Application number: 2023/93305	
What is the application for?:	Erection of first floor extension above existing garage, alterations to an exist
Address of the site or building:	6, Lea Drive, Shepley, Huddersfield, HD8 8HA
Postcode:	HD8 8HA

Planning Application: 2023/93305

BLOCK PLAN - 1:200

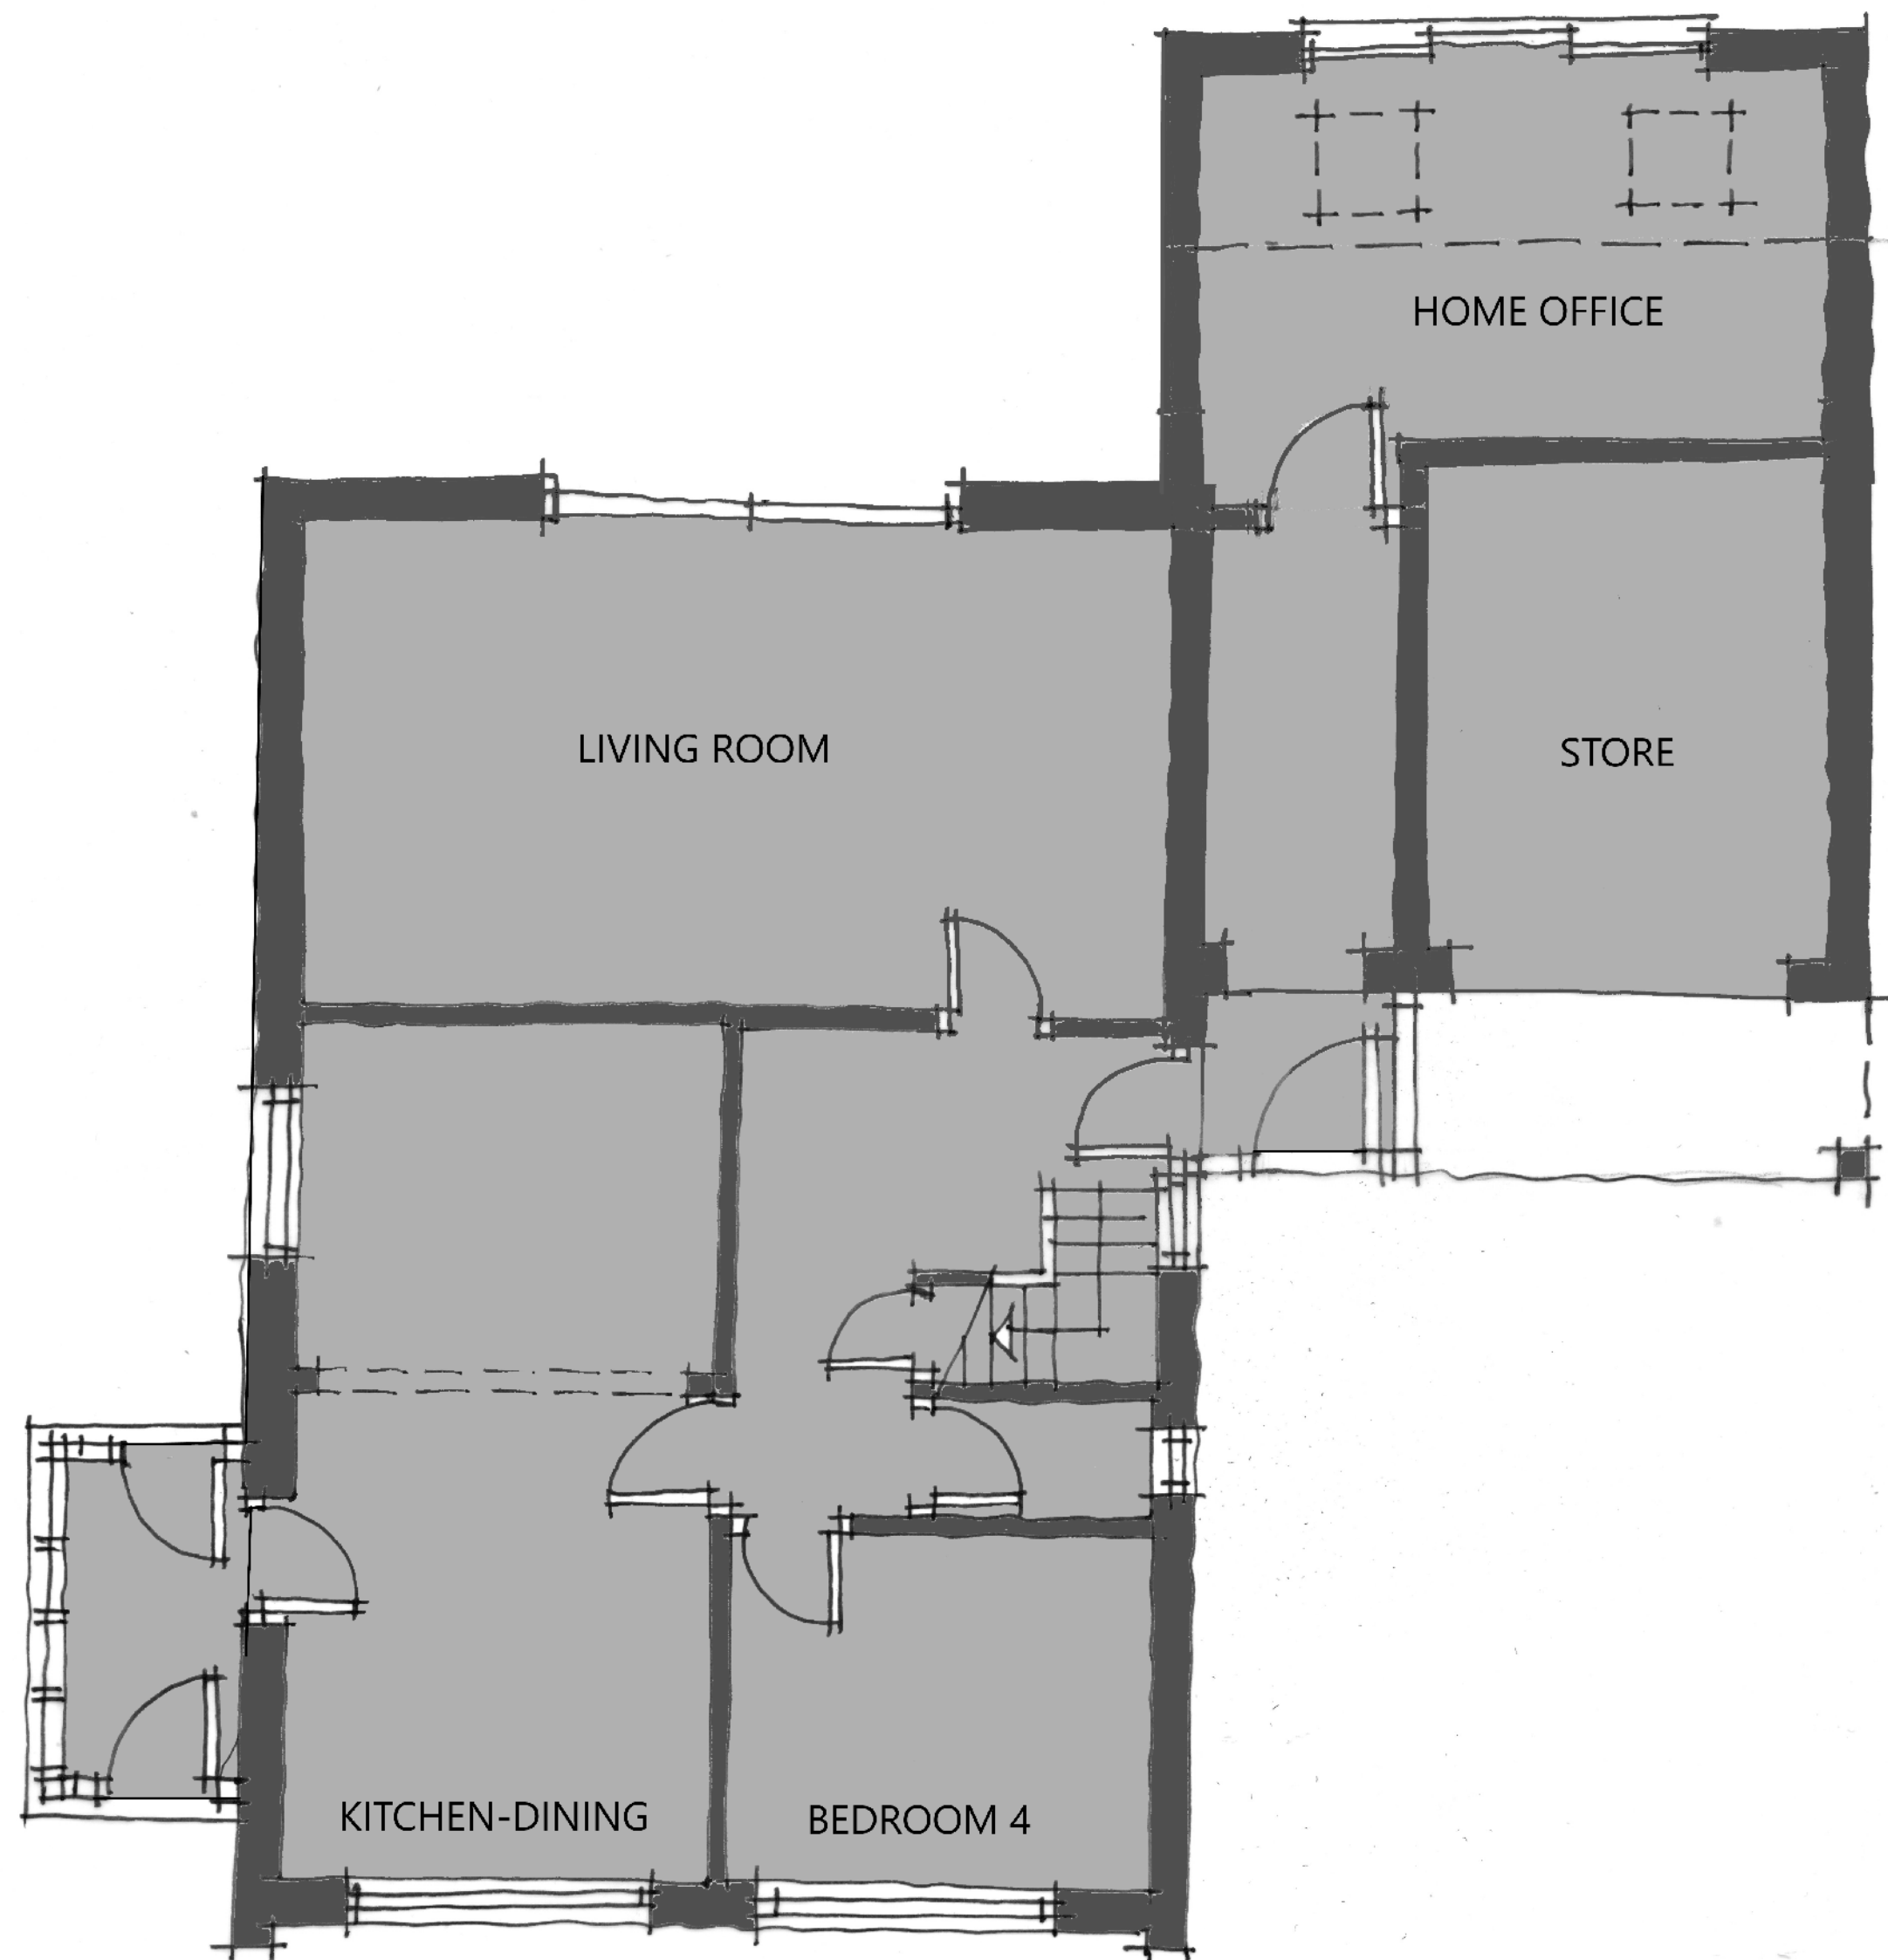
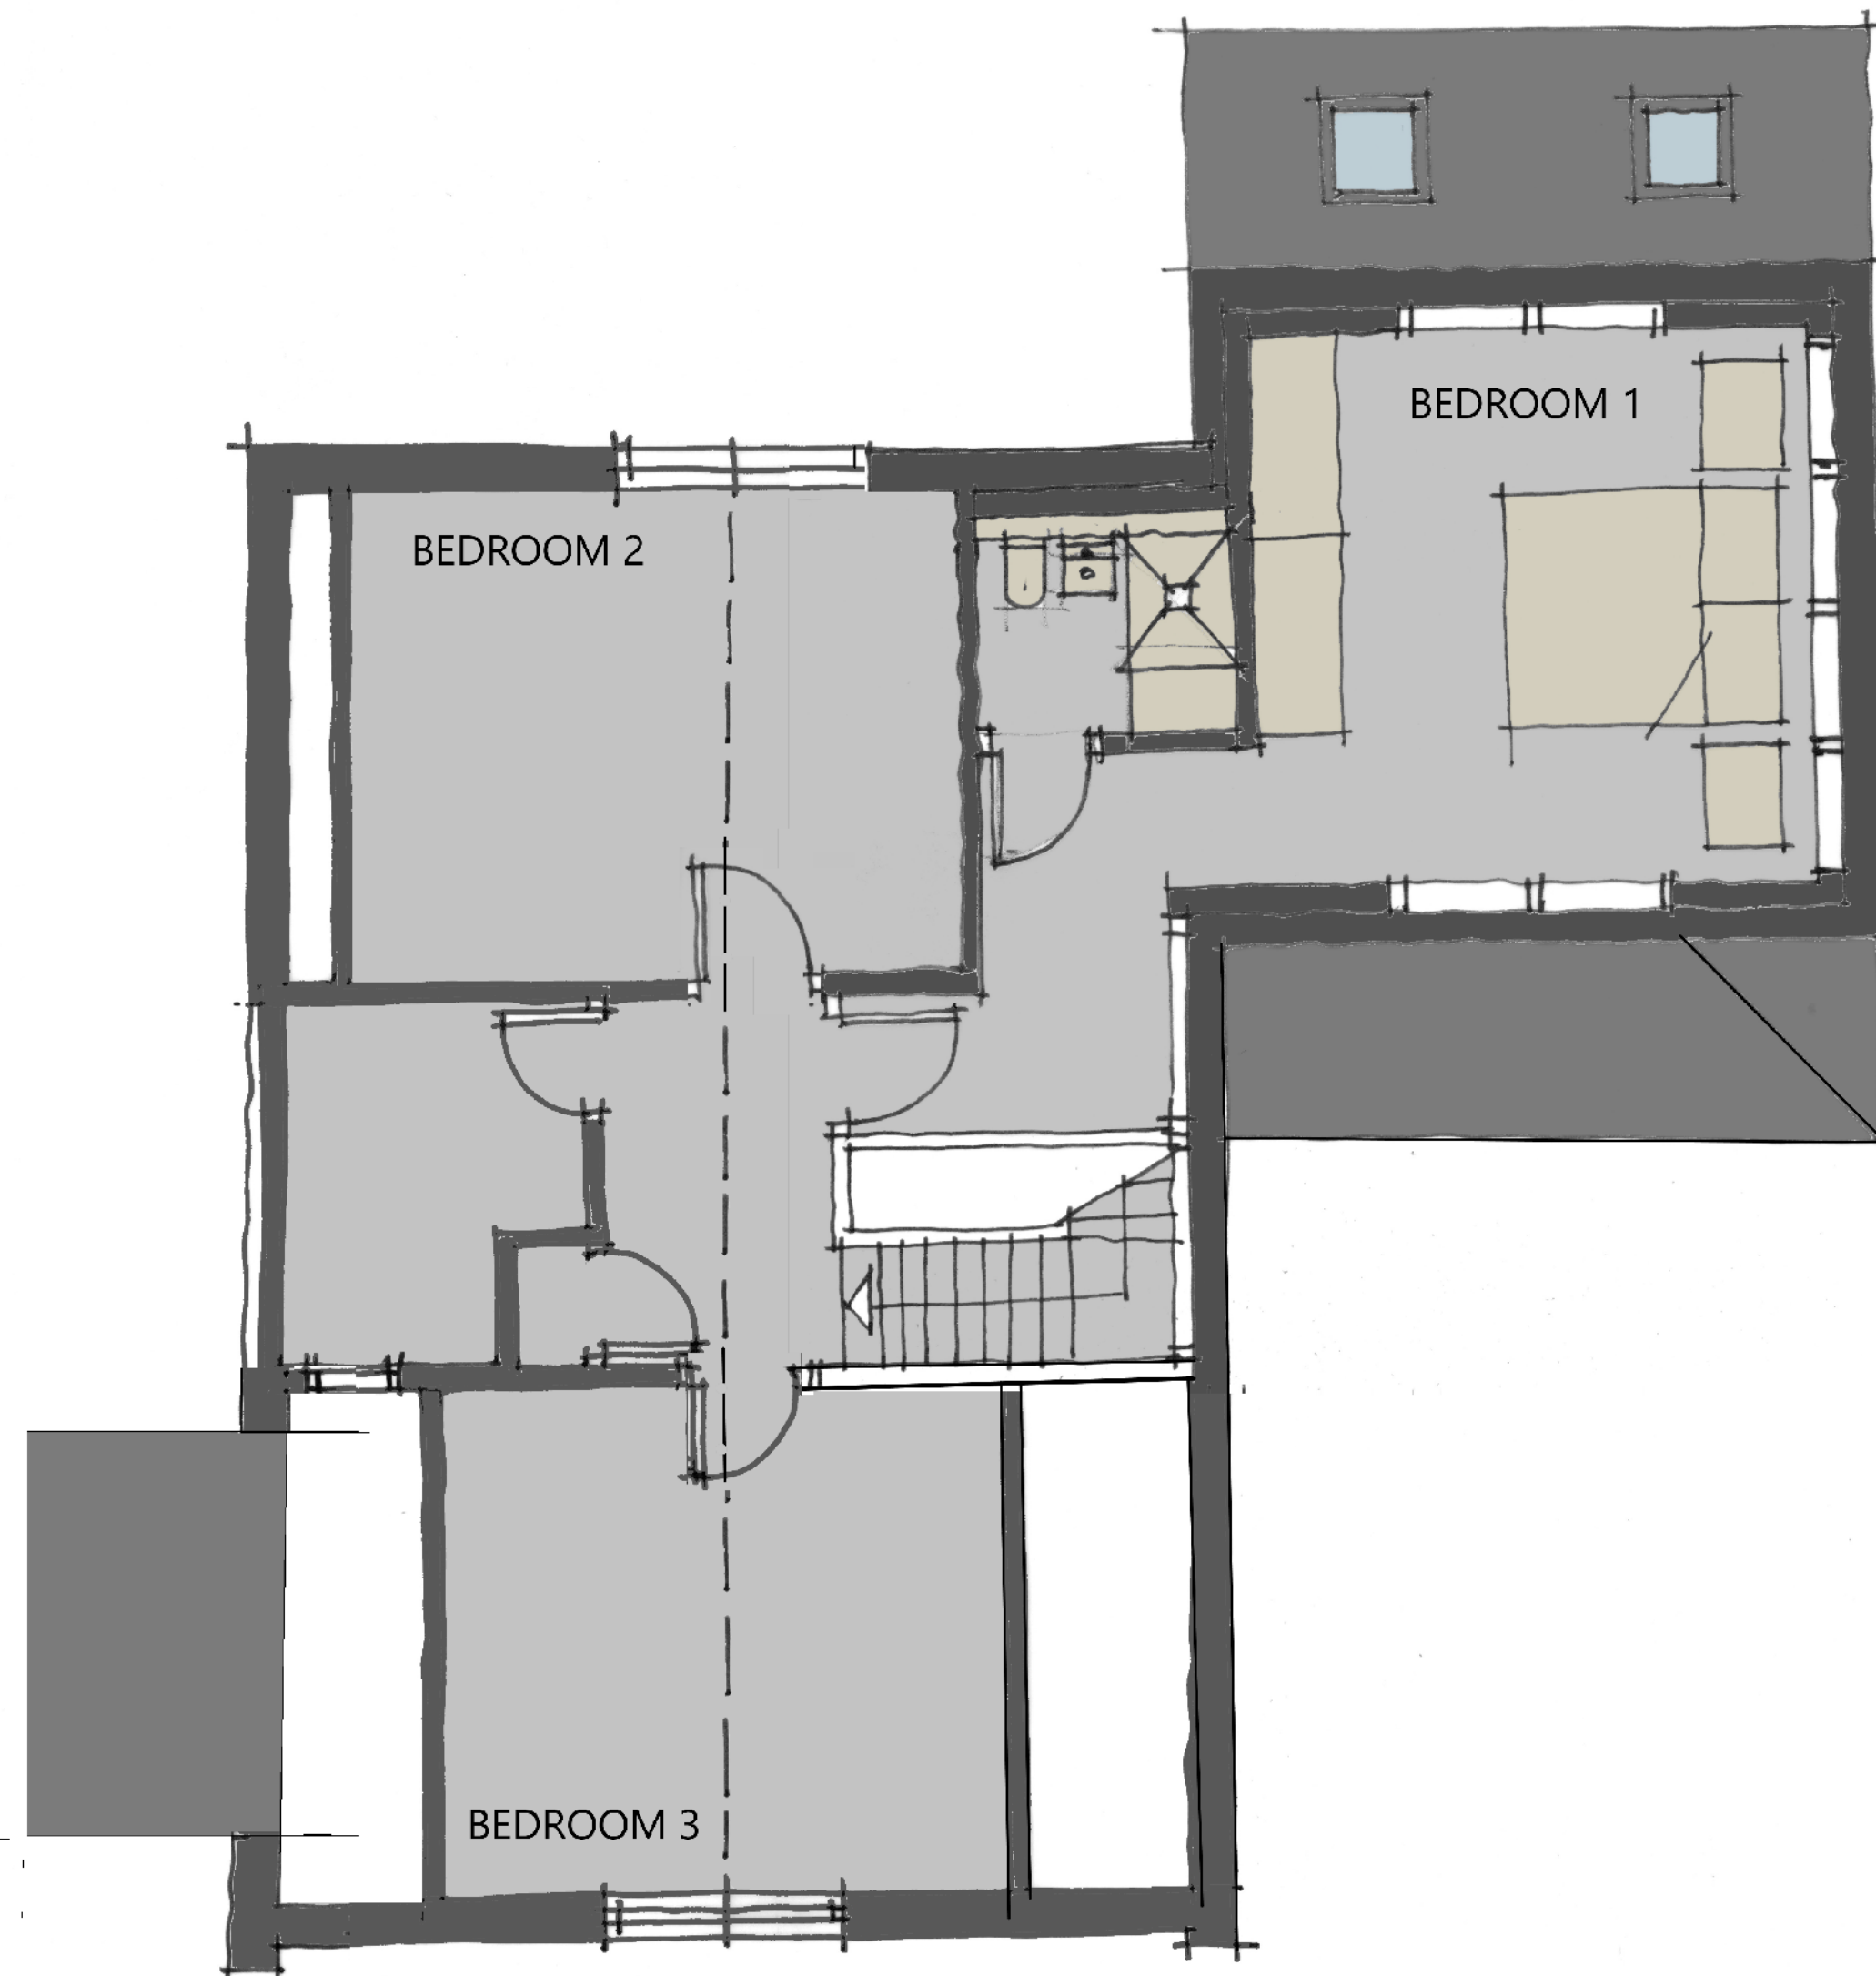
3. The design/plan submitted isn't to scale and doesn't fairly show the type or size of our property (it doesn't show that the front 60% of our property is a bungalow, and it also shows that it is much larger than it is). The floor area of our property is the same size as Number 8 on the plans submitted.
